State of Washington
DEPARTMENT OF FISH AND WILDLIFE

SUBJECT: WDFW COMMENTS ON SP-23-00012

Thank you for the opportunity to comment on SP-23-00012 concerning the proposal to create two lots from Parcels #955862 and # 960889. Washington Department of Fish and Wildlife (WDFW) has reviewed the application and supporting documents. Our comments are regarding the project's impact on priority fish and wildlife habitats, particularly wetlands and riparian habitats. Specifically, to ensure that if the application is approved that the development of new parcels will not result in loss of Fish and Wildlife Habitat Conservation Areas (FWHCA) under Kittitas County Critical Areas Ordinance (CAO).

KD PROPERTIES SHORT PLAT

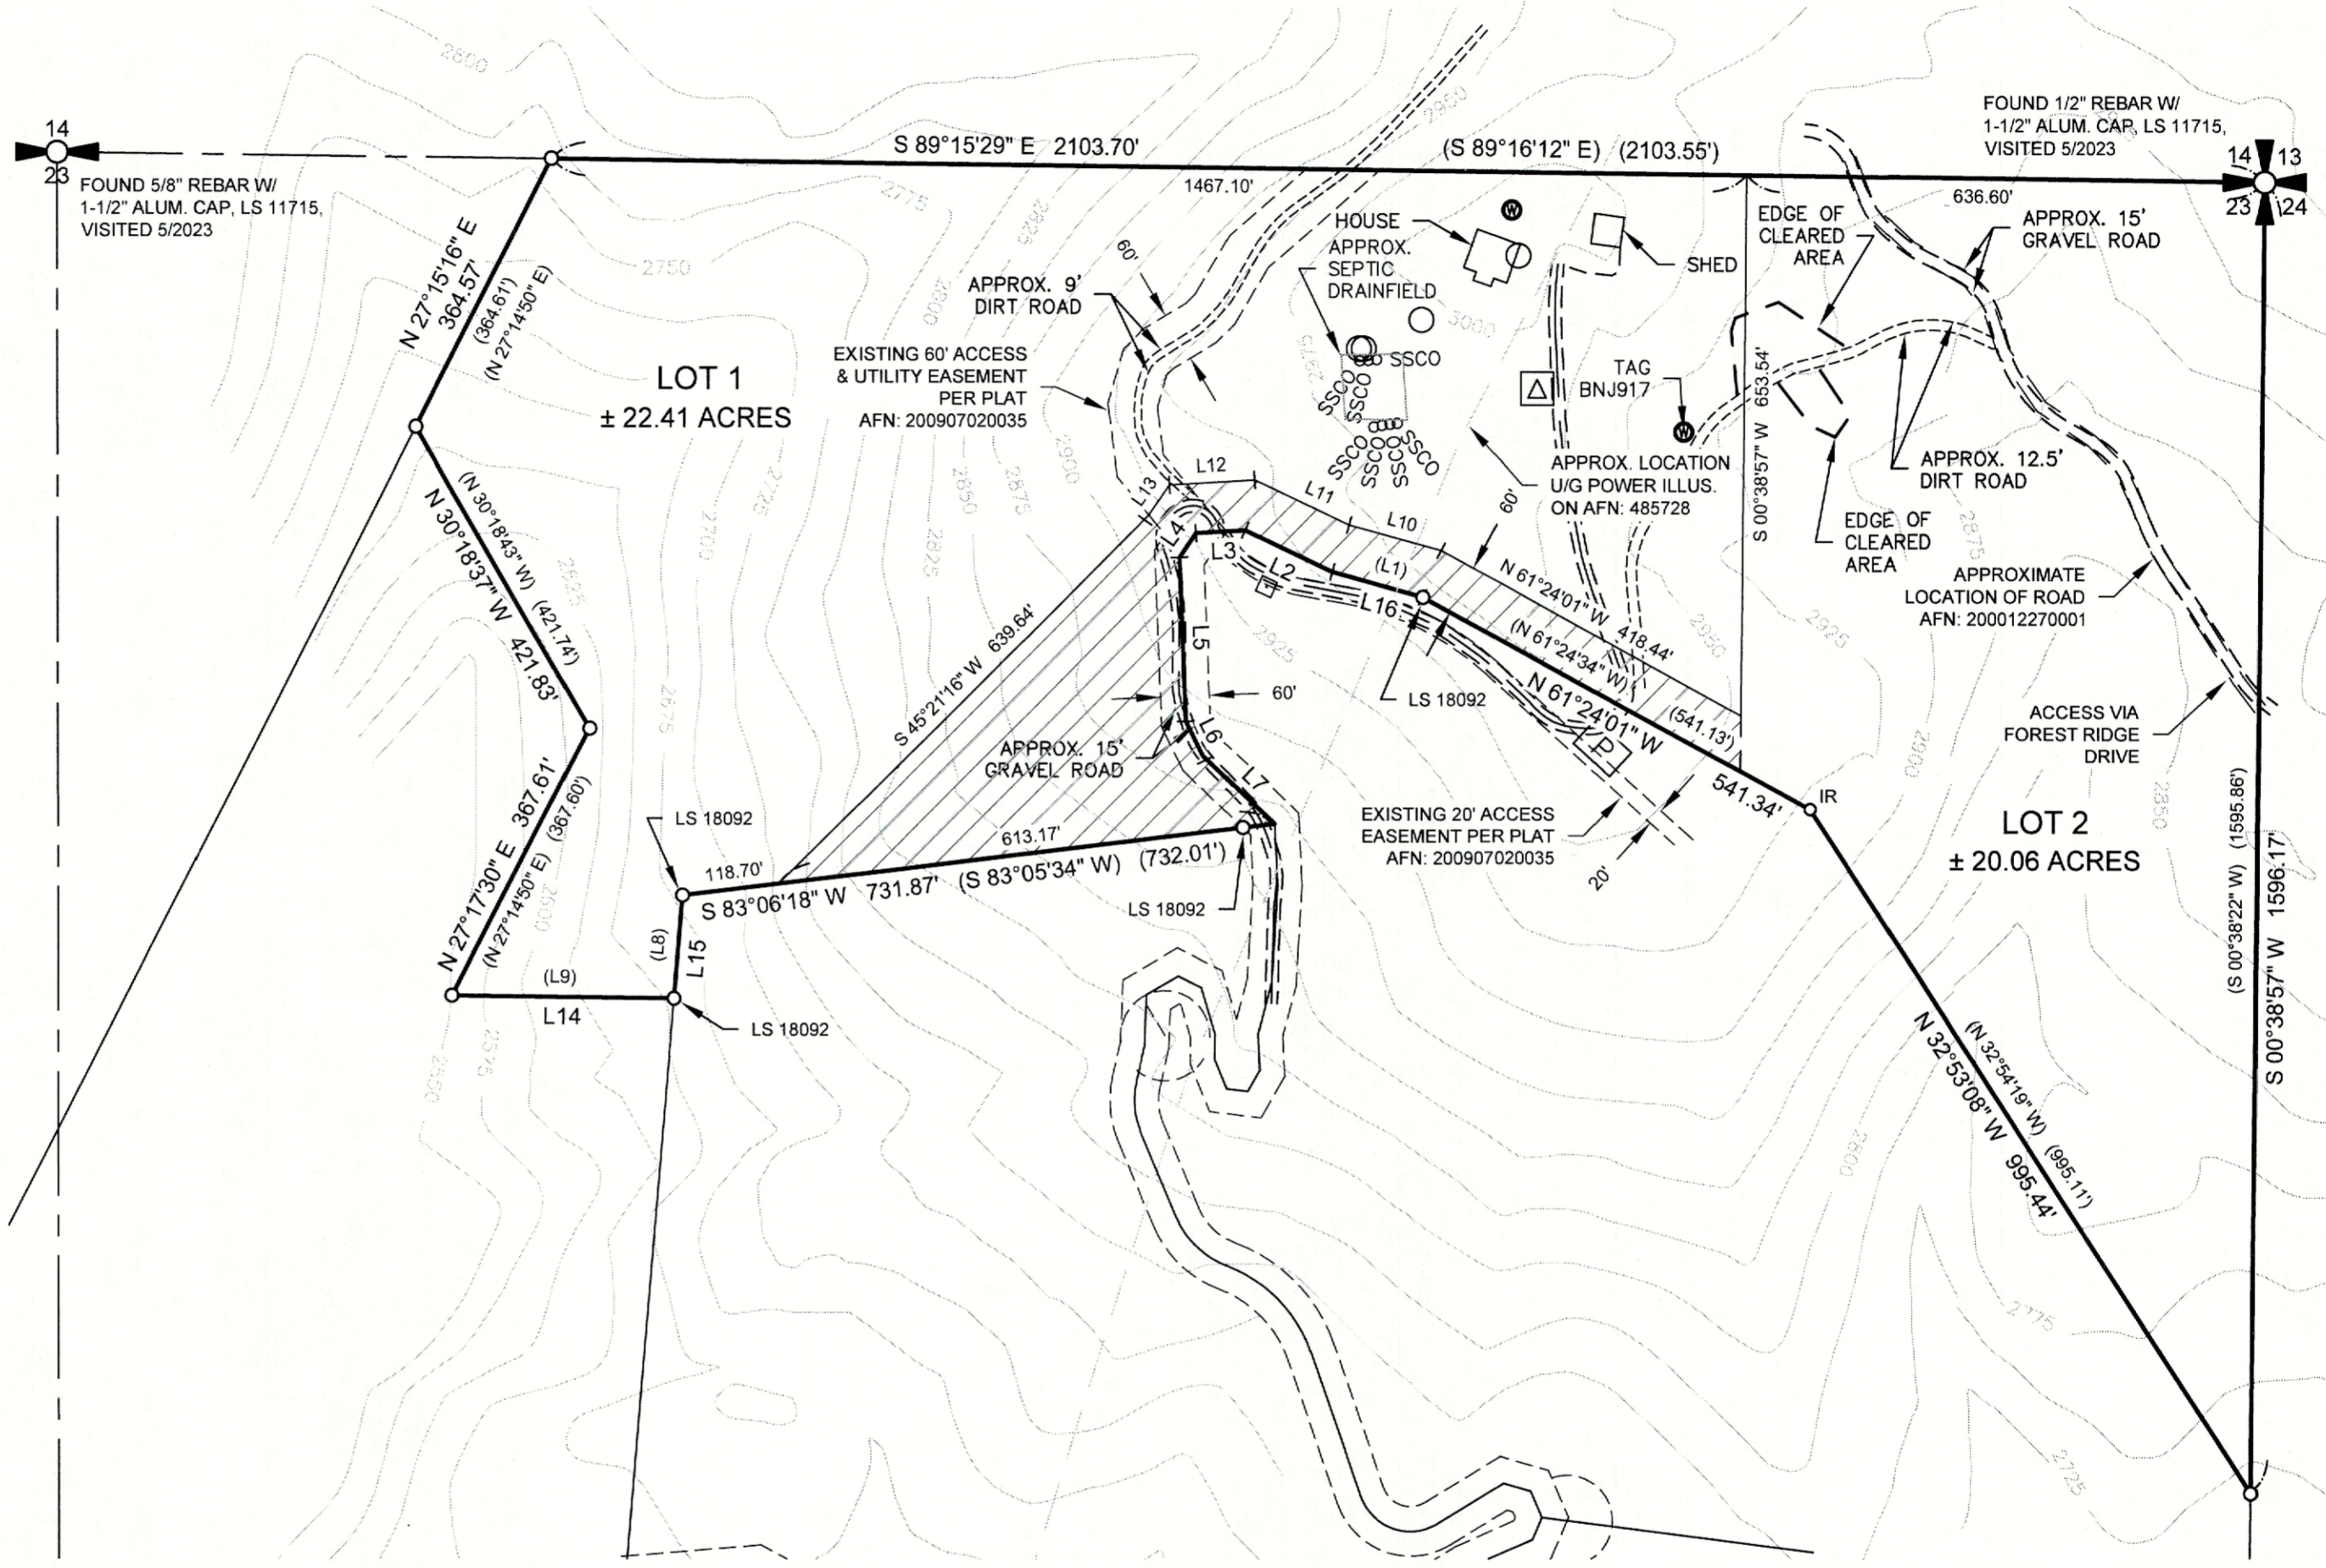
There are currently two Type Ns (non-fish-bearing seasonal) creeks mapped on the Washington Department of Natural Resources (WDNR) stream layer on the parcel, yet it appears that neither is shown on the critical areas map provided in the project application. Further, WDFW has been part of stream investigations in the surrounding area and has found streams and wetlands that are not on existing maps. WDFW requests that a critical areas report be conducted prior to approval to ensure that all streams and wetlands are identified, and their appropriate buffers factored in to ensure that both new parcels have buildable area after factoring in the CAO setbacks. WDFW would also request the opportunity to review and provide comments to the county on the report.
